**KIRKLEES METROPOLITAN COUNCIL
INVESTMENT & REGENERATION SERVICE**

**DELEGATED DECISION TO DETERMINE APPLICATIONS FOR
CONSENT, AGREEMENT OR APPROVAL REQUIRED BY CONDITION**

Reference No:	2024/44/92576/W
Site Address:	site of, Former Spotted Cow Pub, New Hey Road, Oakes, Huddersfield, HD3 4BU
Description:	Discharge of details reserved by conditions 3 (CMP), 21 (retaining walls), 23 (surface water) and 28 (non-native species) of previous permission 2021/94029 for demolition of existing structures and erection of foodstore (class E) with associated access, parking, servicing areas and landscaping
Recommending Officer:	Victor Grayson

DECISION – Discharge of Condition – Split Decision

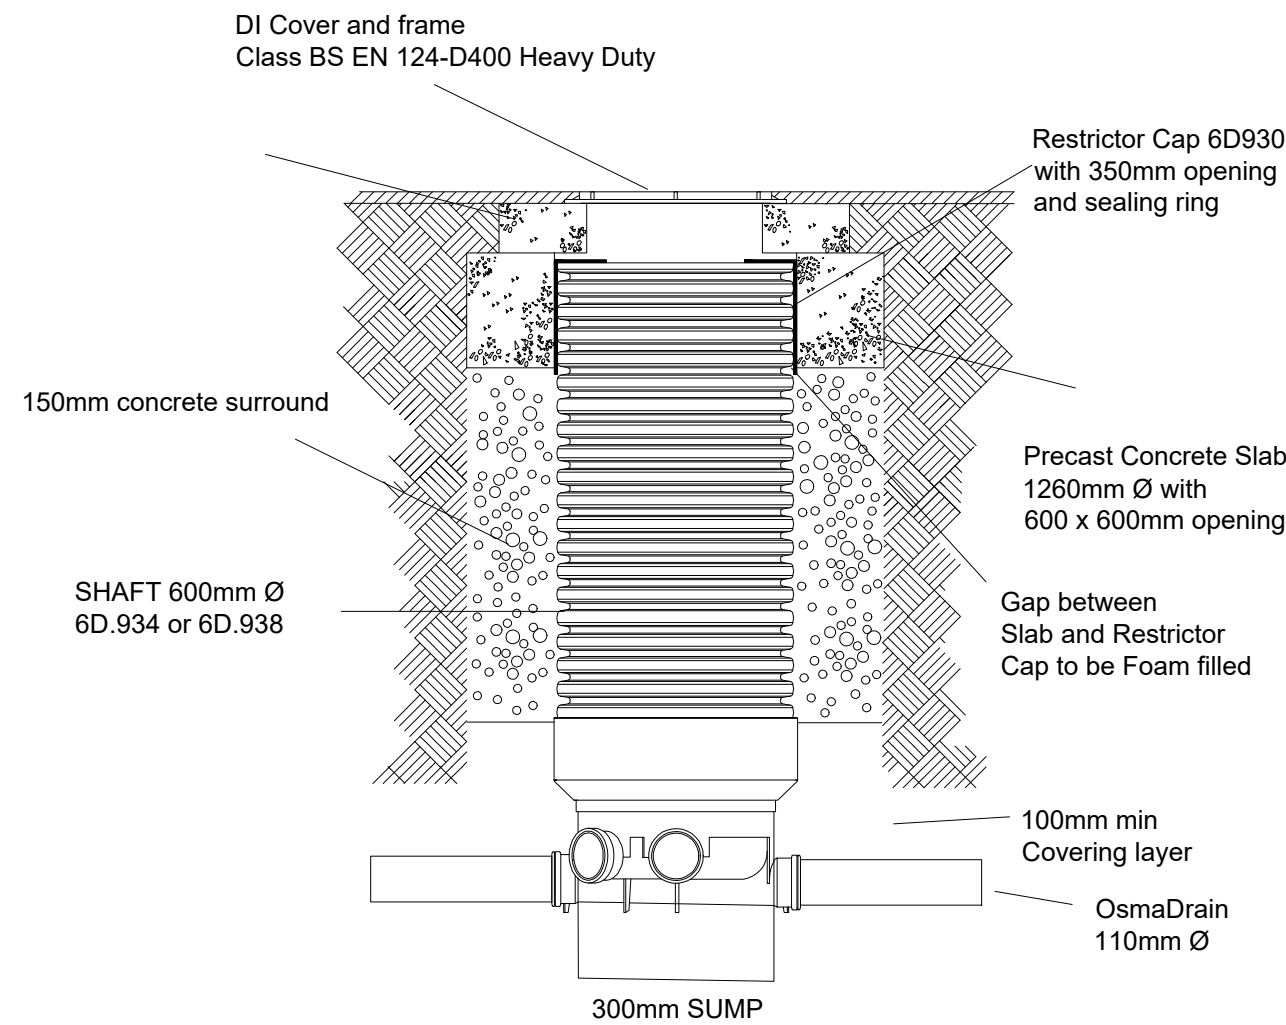
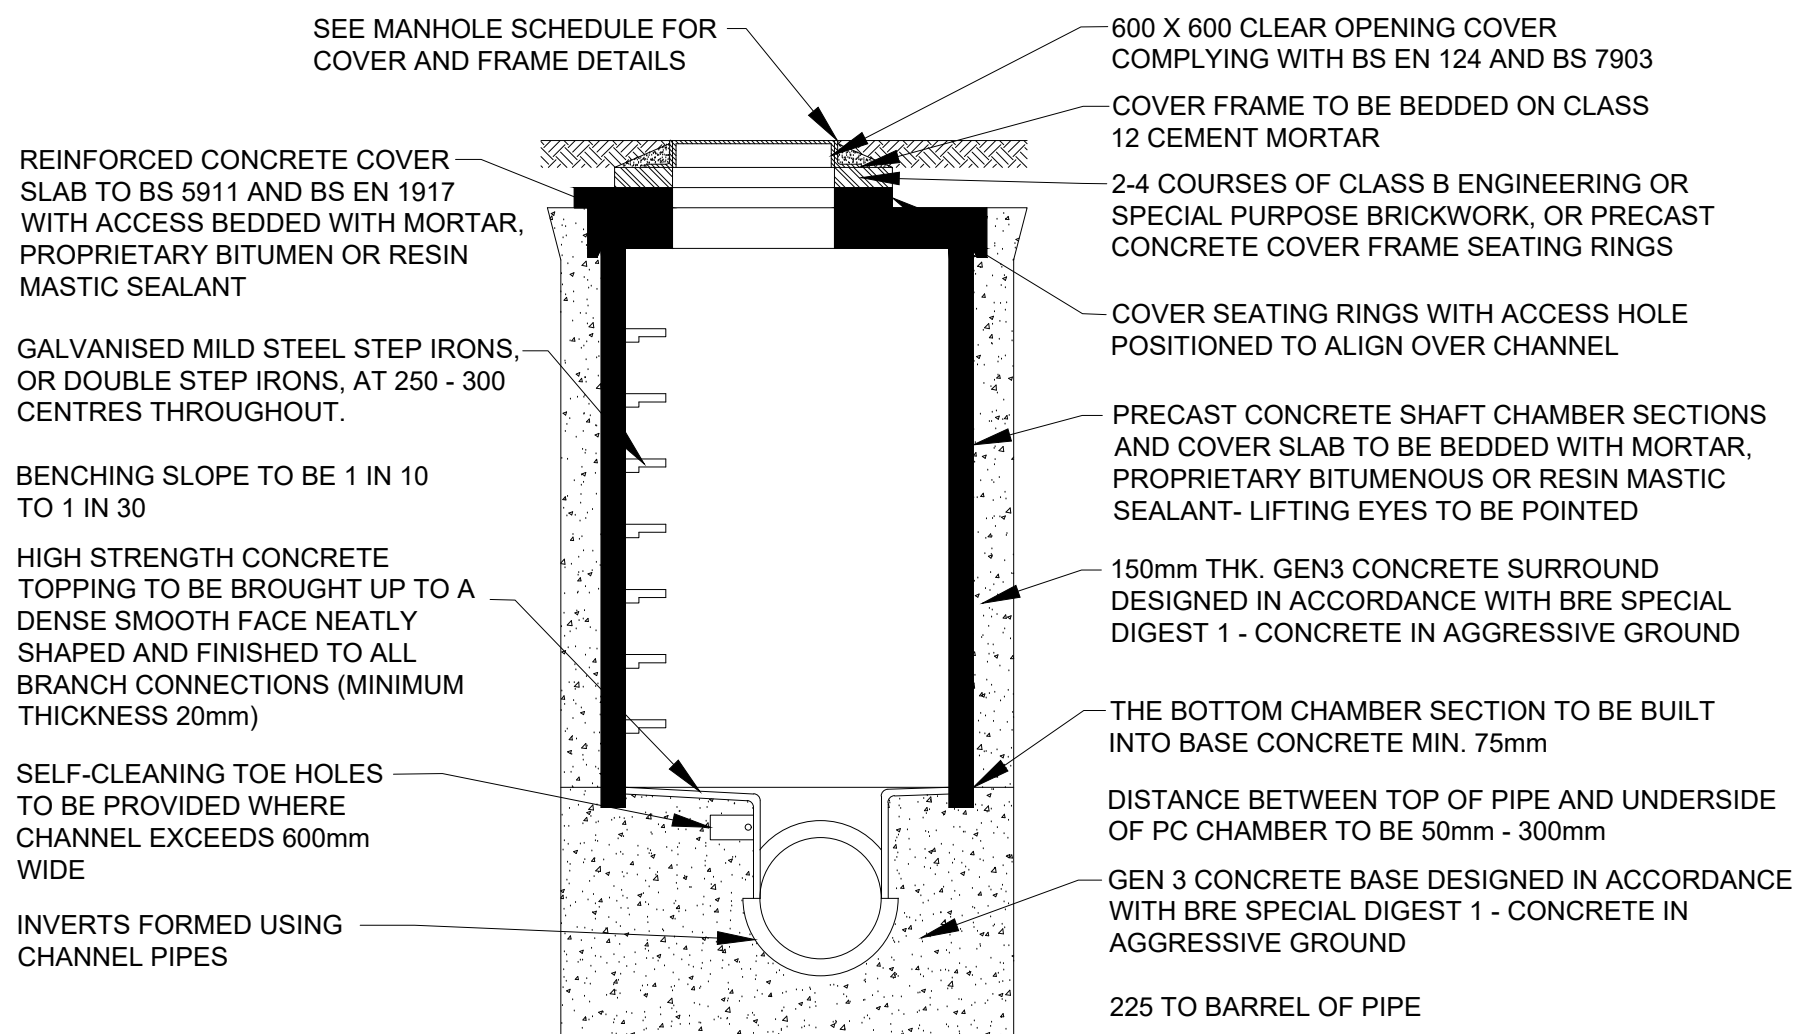
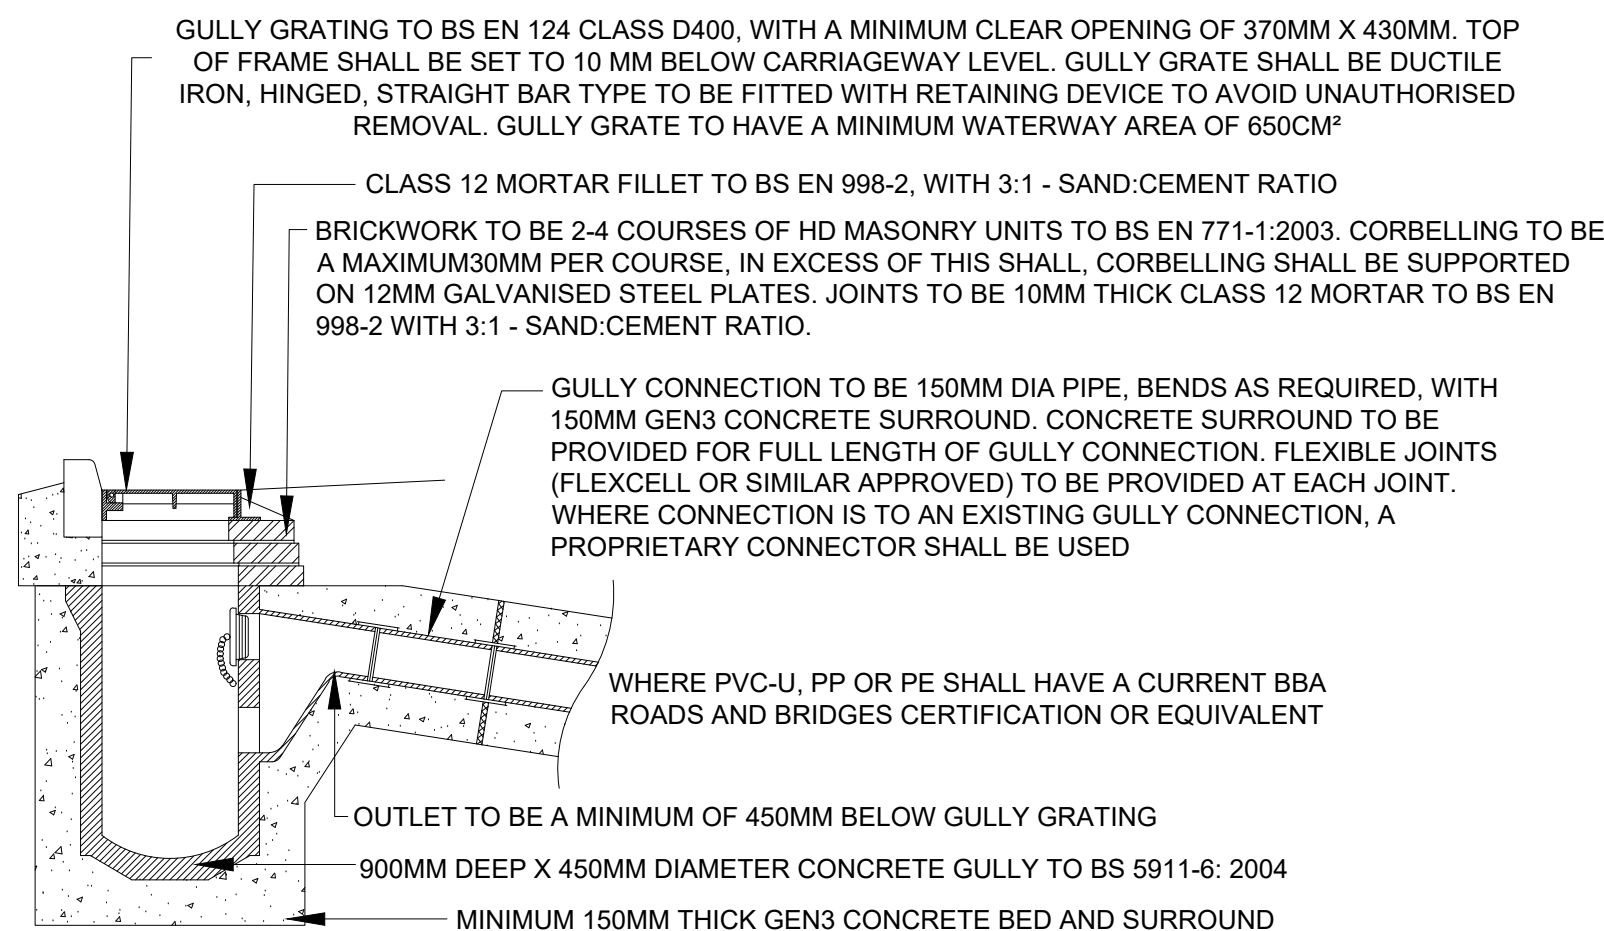
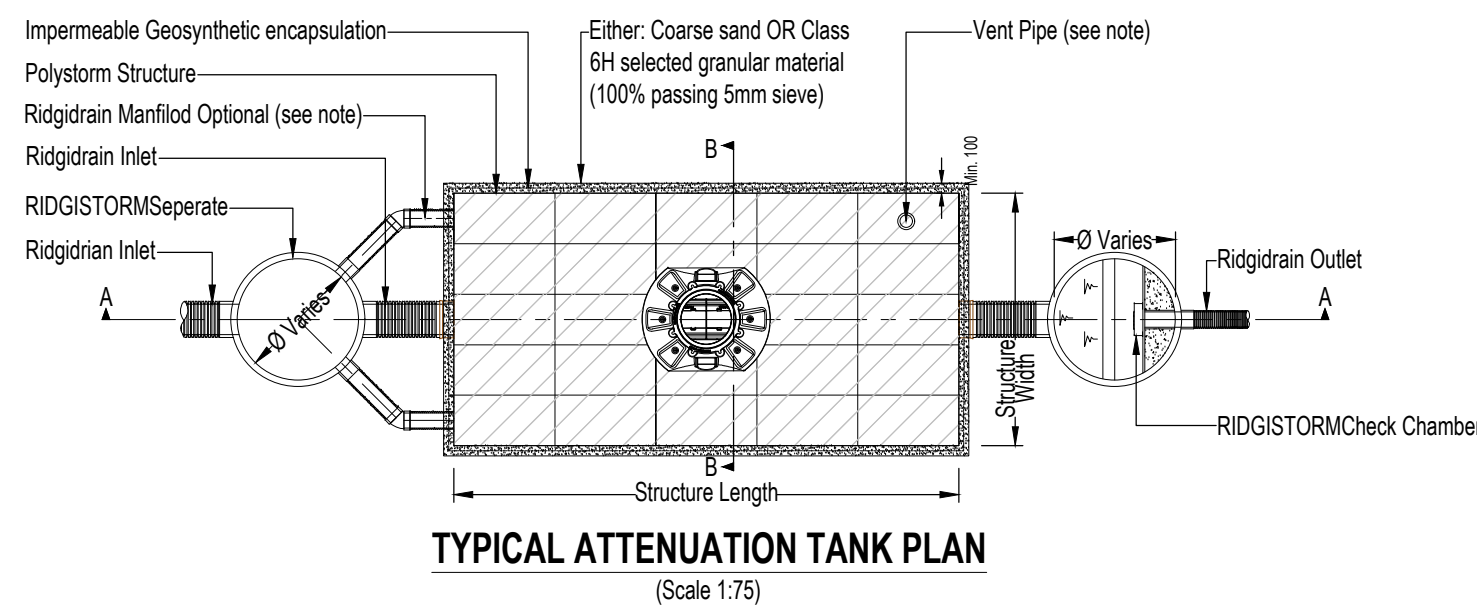
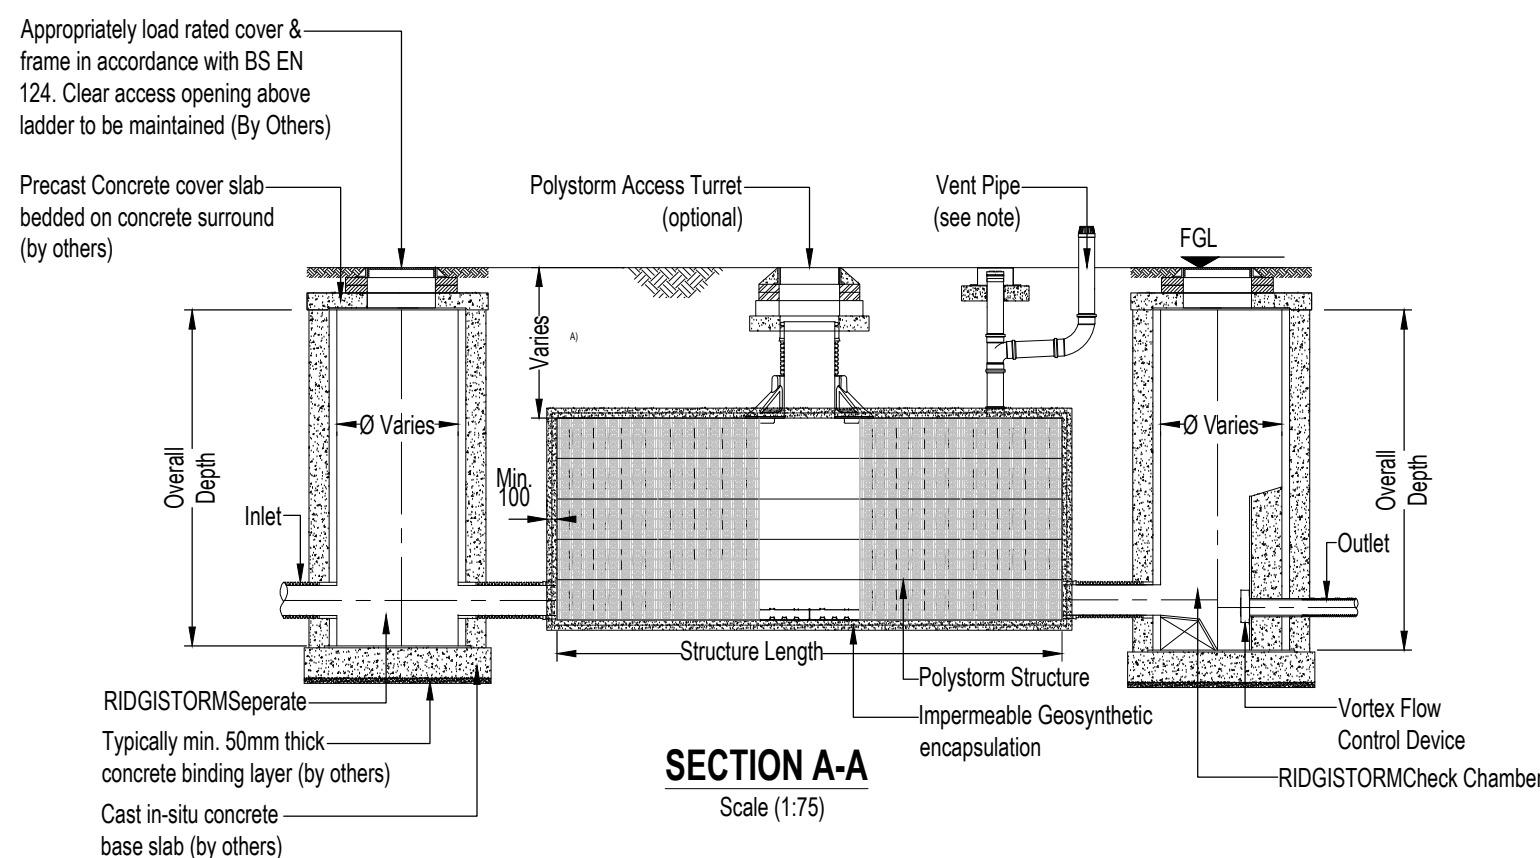
The LLFA have provided comments dated 25/10/2024, 01/12/2024, 05/01/2025 and most recently on 07/02/2025. In their earlier comments, the LLFA raised concerns (or requested further information) regarding the proposed use of cellular storage, maintenance of drainage infrastructure, certain proposals being “indicative”, modelling, and oil/petrol interceptors. In their most recent

An assessment of the max weight of vehicles to be visiting the site (HGVs, e.g. delivery trucks) in relation to minimum depths required from Polystorm R has been supplied. A protective slab is also now included. Access into the crate storage is now shown for both attenuation features.

Many of the maintenance concepts are not relevant to the design selected (suggests green suds) which suggests this wasn't a bespoke maintenance plan. However, the relevant areas are acknowledged and is accepted without prejudice to future applications. Catchpit manholes are shown on the drawings.

The oil and petrol interceptor is now independent of roof drainage prior to the flow control. A relevant product has been selected from the manufacturer's brochure.

Given the above assessment, it is recommended that an approval be issued pursuant to condition 23. It is also recommended that the applicant be reminded of the further stipulations of condition 23, which are:
